Biala Wind Farm

RESPONSE TO SUBMISSIONS

February 2016

Report prepared for Newtricity

APPENDIX 2 DEVELOPMENT LAYOUT

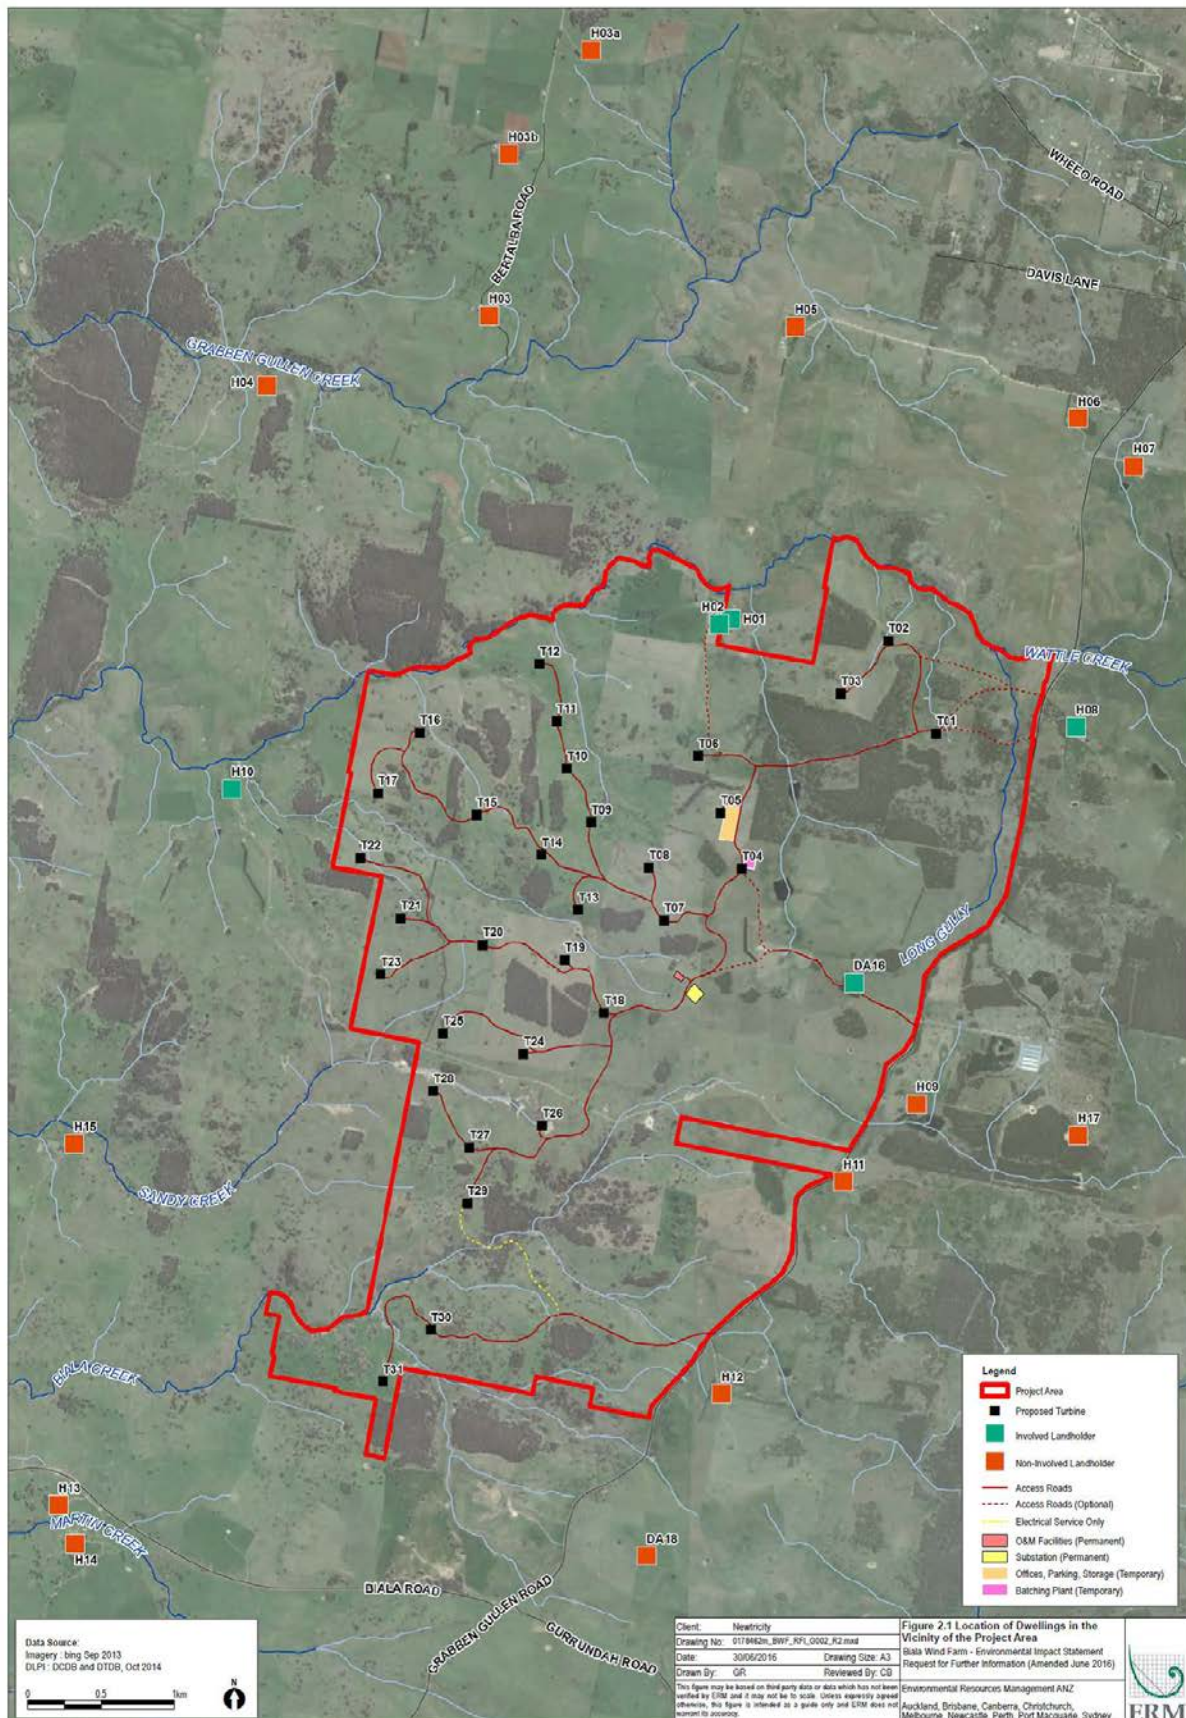
The ULSC submission (refer *Annex A*) provided a number of comments and concerns regarding sight distance provisions of the proposed site access points off Grabben Gullen Road, which outlined the following in regards to this issue:

"Section 4.5.2: Sight distance - is substandard at the northern most and southern accesses. The proponent has suggested that a speed limit could be utilised to reduce sight distance requirements. ULSC property access standards require that an 85th percentile speed of 70 km/hr exists for a sight distance of 150 m. Unfortunately it is unlikely that motorists would obey such a speed limit in an isolated situation. To overcome this, the proponent must consider 'micrositing' the accesses to improve sight distance."

The previously proposed northern access point had approximately 150 m available sight distance to the south, less than the 250 m required by Austroads.

The previously proposed southern access had approximately 150 m available sight distance to the north, less than the 250 m (approx.) required by Austroads. It was therefore determined that the access point would need to be relocated either to the north or the south to meet the design objectives.

It was agreed that the central access could be relocated further to the south to improve the available sight distance. The sight distance at the revised central access exceeds the minimum requirements for a 100 km/h road set out in Austroads.

Due to a number of existing constraints, including land ownership, it was concluded that the access would need to be relocated approximately 200 m to the north. The sight distance at the revised southern access meets the minimum requirements for a 100 km/h road set out in Austroads.

The revised central and southern vehicle access point locations, as determined collaboratively with ULSC, exceed the sight distance requirements set out in Austroads.

The revised locations for the northern, central and southern vehicle access points are illustrated in *Figure 4.1*. This figure also incorporates the removal of the previously proposed internal road connection between Wind Turbine Generators (WTGs) T29 and T30, which is now proposed as an internal electrical service connection only, in order to minimise impacts on Biala Creek, a 3rd order watercourse at this crossing location (identified as Watercourse Crossing 8 in the EIS). This amendment was made in response to DPI responses and in discussion with DPE, and further detail is provided in *Table 4.3*.
